The Sizewell C Project

5.2 Main Development Site Flood Risk Assessment Addendum Appendices A-F Part 1 of 10

MAIN DEVELOPMENT SITE FLOOD RISK ASSESSMENT ADDENDUM APPENDICES

APPENDIX B: COLLATED COMMENTS FROM THE ENVIRONMENT AGENCY RECEIVED ON 5TH FEBRUARY 2020 AND 4TH AUGUST 2020

DRAWING TITLE:
MAIN DEVELOPMENT SITE SSSI CROSSING
(UNDER CONSTRUCTION - BAILEY BRIDGE STAGE)

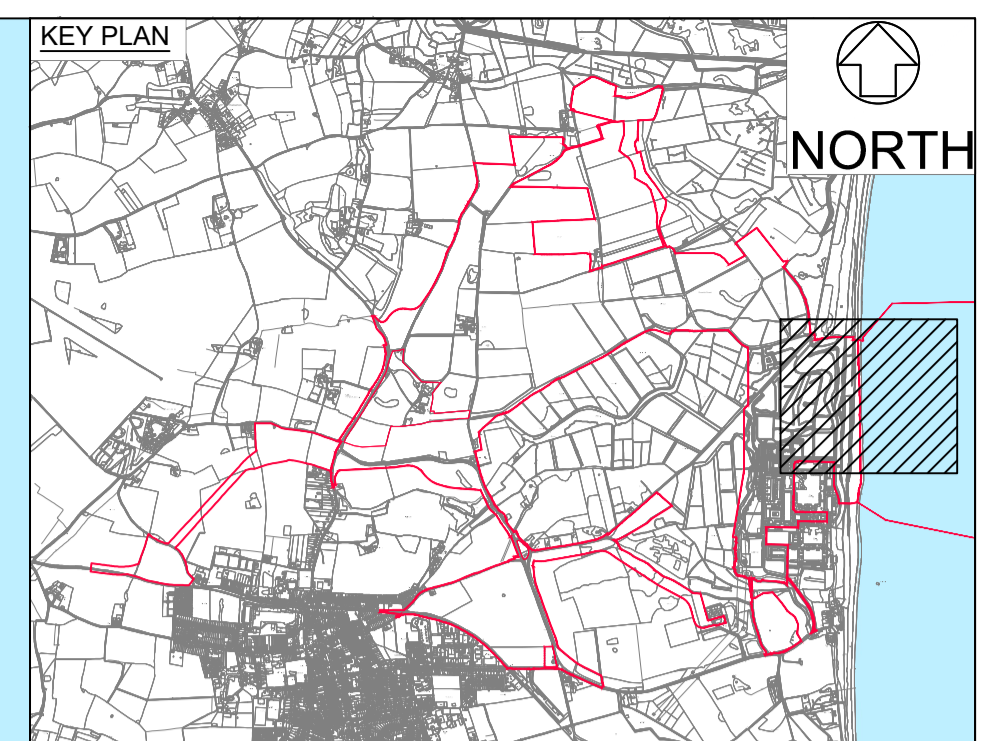
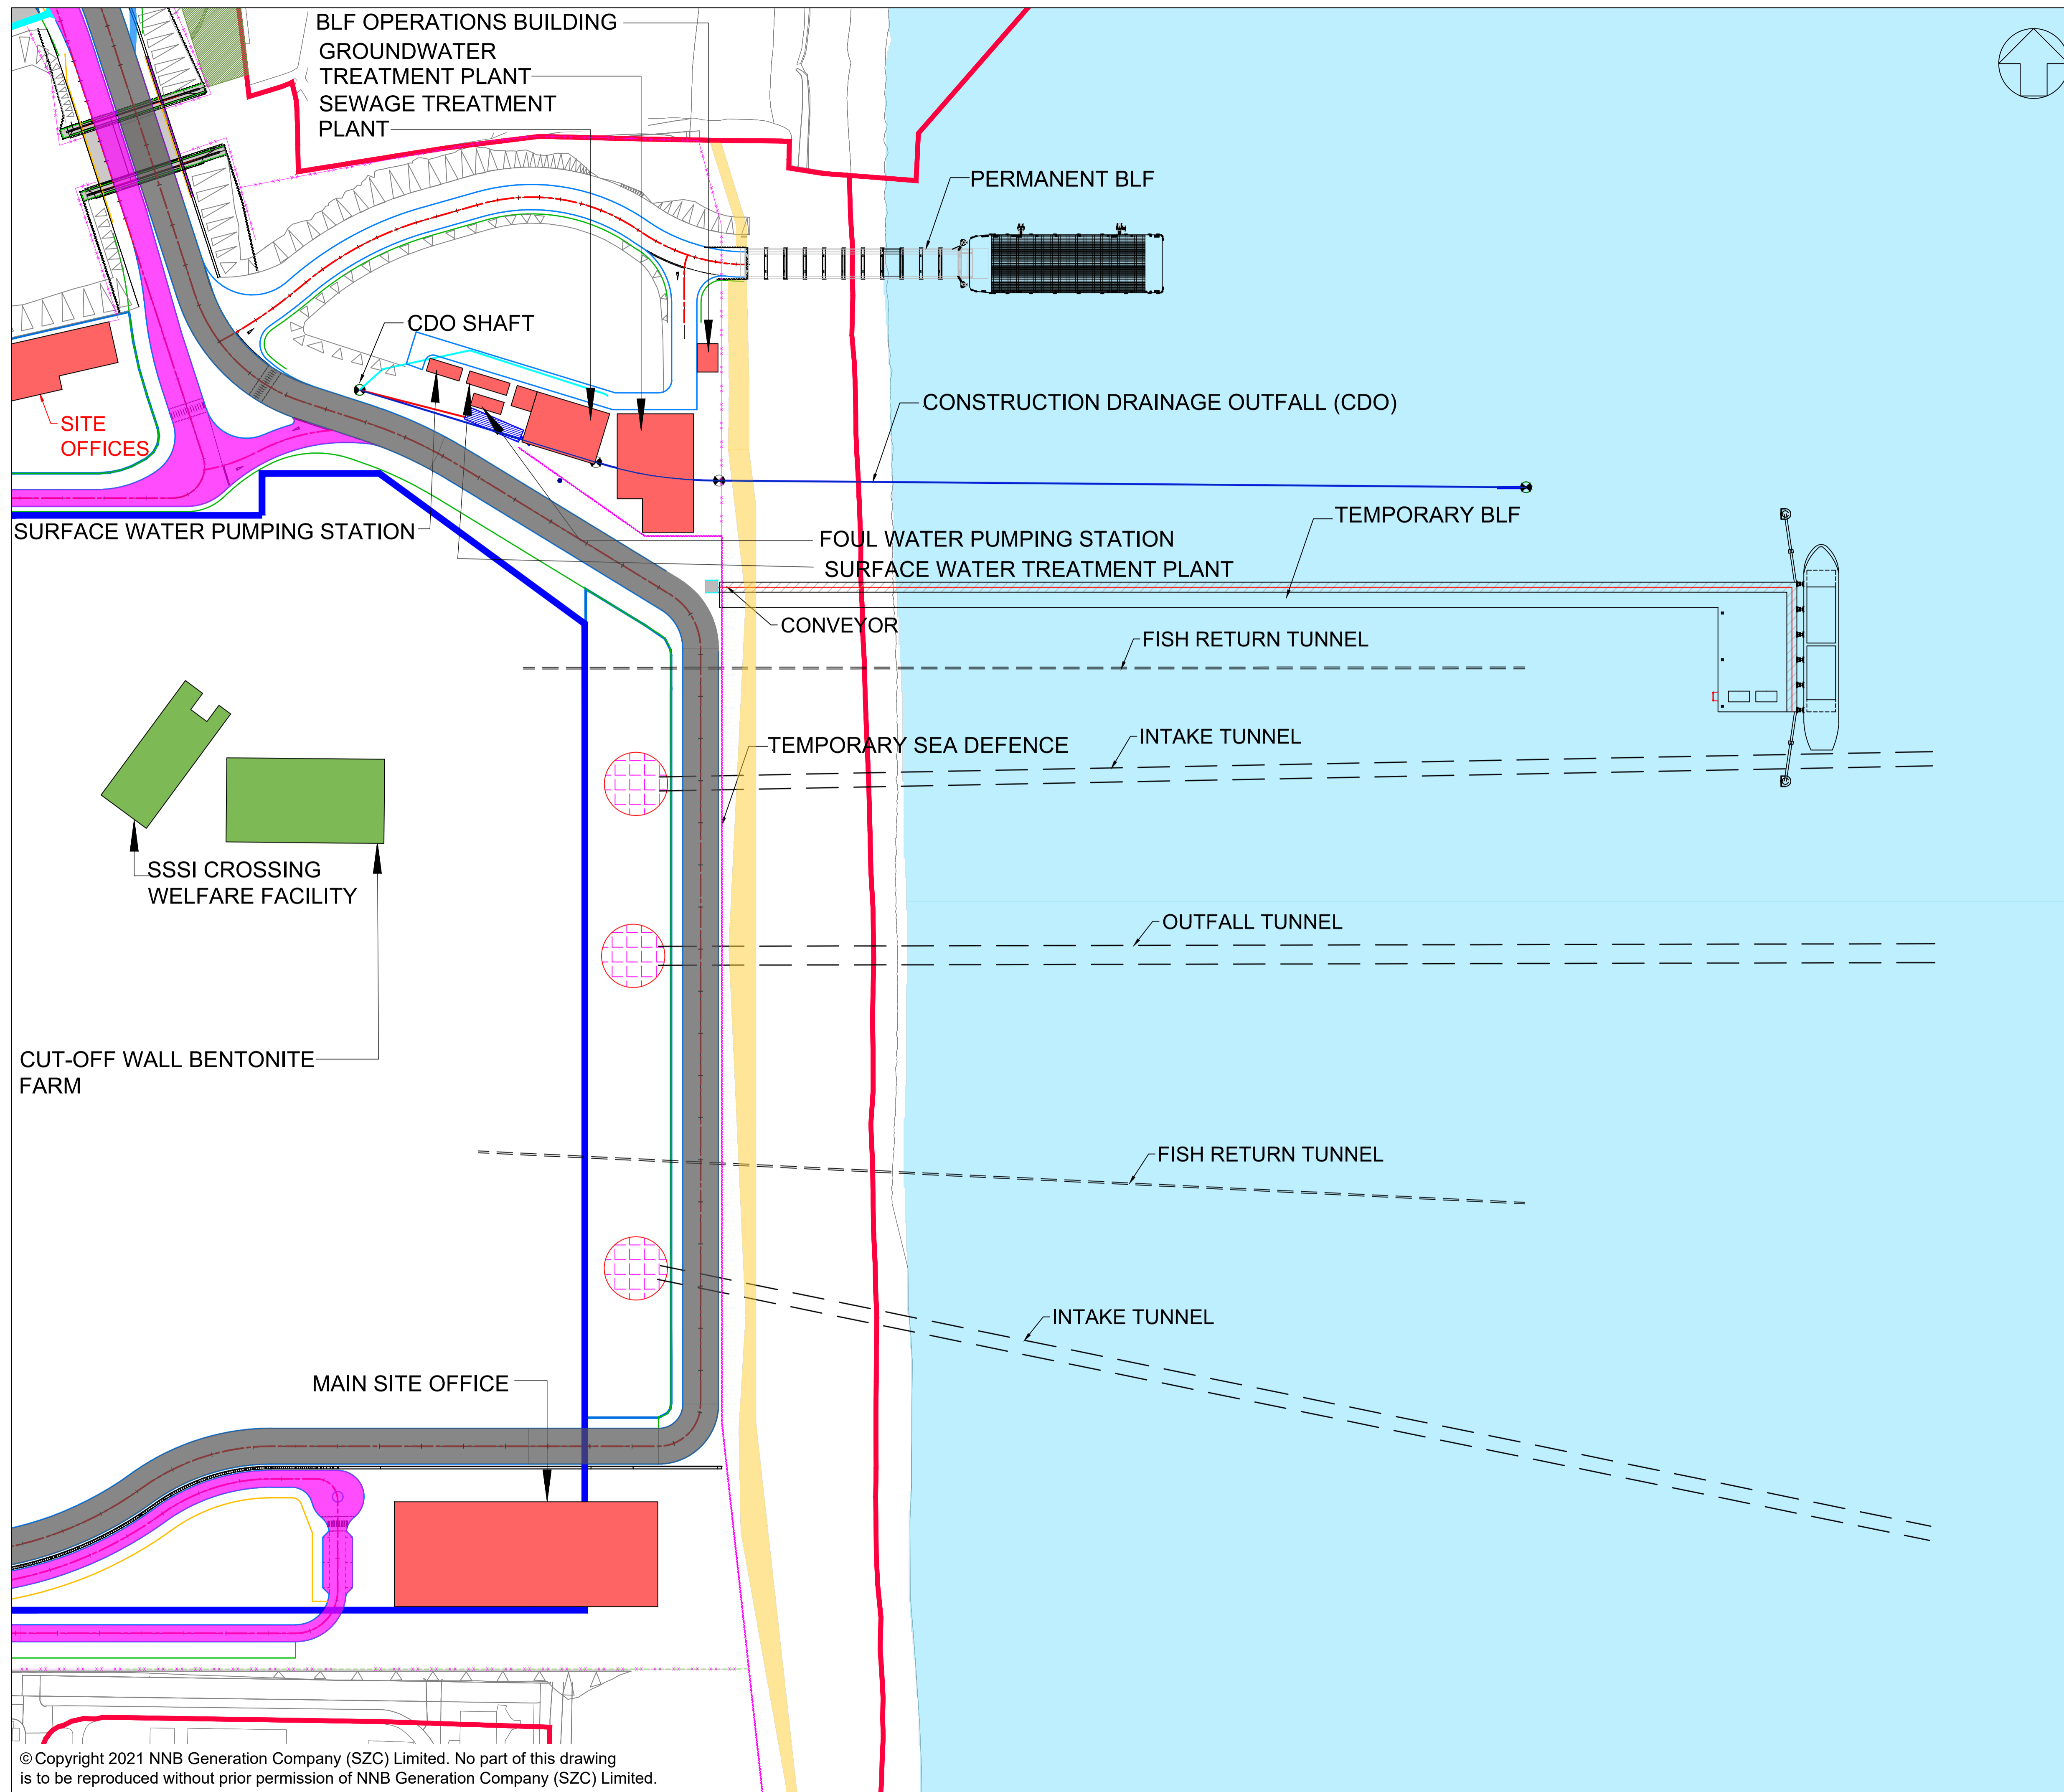
Sizewell C Main Development Site FRA	8.1.11, Table 8.2 & 8.2.7, 8.3.10	The temporary SSSI crossing during construction will be at risk of fluvial flooding and also coastal flooding in the 0.1% event as the existing defences are inundated, and also during a breach flood event.	The risk of fluvial flooding for the area of the temporary SSSI crossing is unclear. 8.3.10 indicates that the levels of the proposed temporary crossing are unknown, but that these should be set above 2.0mAOD in order that the road would remain dry from fluvial flooding (1 in 100yr +25% level 1.86mAOD). However, there is no assessment of the potential implications of fluvial flood risk on the construction site itself, nor for the safety of the construction workers. Para 8.1.13 states a 0.1% still water level of 4.35mAOD, which is above the shingle crest. This is below the level of the proposed haul road (7.3mAOD). However, there will be a period of risk during the early construction phase BEFORE completion of the haul road. For a period of time where this risk will be real and there will be no defences in place. What impacts would this event have at this time and how will this risk be managed?	Explain the fluvial and coastal flood risk posed to the temporary crossing and people using it, for both the risk of fluvial flooding or coastal inundation during the early construction phase, and also in the event of a breach occurring. Ensure there is a safe access/egress or a safe means of escape. Detail how this would be implemented and how people on site will know when to evacuate or stop work. A breach flood can occur without warning.

6.1	Sizewell C Main Development Site FRA	8.1.11, Table 8.2 & 8.2.7, 8.3.10	The temporary SSSI crossing during construction will be at risk of fluvial flooding and also coastal flooding in the 0.1% event as the existing defences are inundated, and also during a breach flood event.	The risk of fluvial flooding for the area of the temporary SSSI crossing is unclear. 8.3.10 indicates that the levels of the proposed temporary crossing are unknown, but that these should be set above 2.0mAOD in order that the road would remain dry from fluvial flooding (1 in 100yr +25% level 1.86mAOD). However, there is no assessment of the potential implications of fluvial flood risk on the construction site itself, nor for the safety of the construction workers. Overtopping risk: Para 8.1.13 states a 0.1% still water level of 4.35mAOD, which is above the shingle crest. This is below the level of the proposed haul road (7.3mAOD). However, there will be a period of risk during the early construction phase BEFORE completion of the haul road. For a period of time where this risk will be real and there will be no defences in place. What impacts would this event have at this time and how will this risk be managed? Breach risk from main defence: 8.2.2 and 8.2.3 state no on site risk to SSSI crossing resulting from breach in 'with scheme' breach outputs in 2030 as height of dev above max water levels. Tank traps breach: 8.2.3 discusses max water levels of 5.7 and 6mAOD (0.5% and 0.1% 2190), but Table 8.2 has water depths and states Danger to All in 2030 and 2190. What are the implications of this for the safety of the site, and how will this risk be managed? Appendix D of the EA & ONR Joint Advice Note (July 2017) states that Safe assess /egress must be provided in the 0.5% tidal flood and 1% fluvial flood with an allowance for climate change. A safe means of escape (or sufficient time available) must be provided up to the 0.1% fluvial and tidal event.	Explain the fluvial and coastal flood risk posed to the temporary crossing and people using it, for both the risk of fluvial flooding or coastal inundation during the early construction phase, and also in the event of a breach occurring. Ensure there is a safe access/egress or a safe means of escape. Detail how this would be implemented and how people on site will know when to evacuate or stop work. A breach flood can occur without warning.	2	GD	01/07/2020	Construction phase assessed in the FRA Addendum (section 4 and Appendix F). Further details included (i.e. temporary coastal defence with minimum crest at 7.3m AOD and temporary bailey bridge at SSSI crossing with level above 2m AOD.
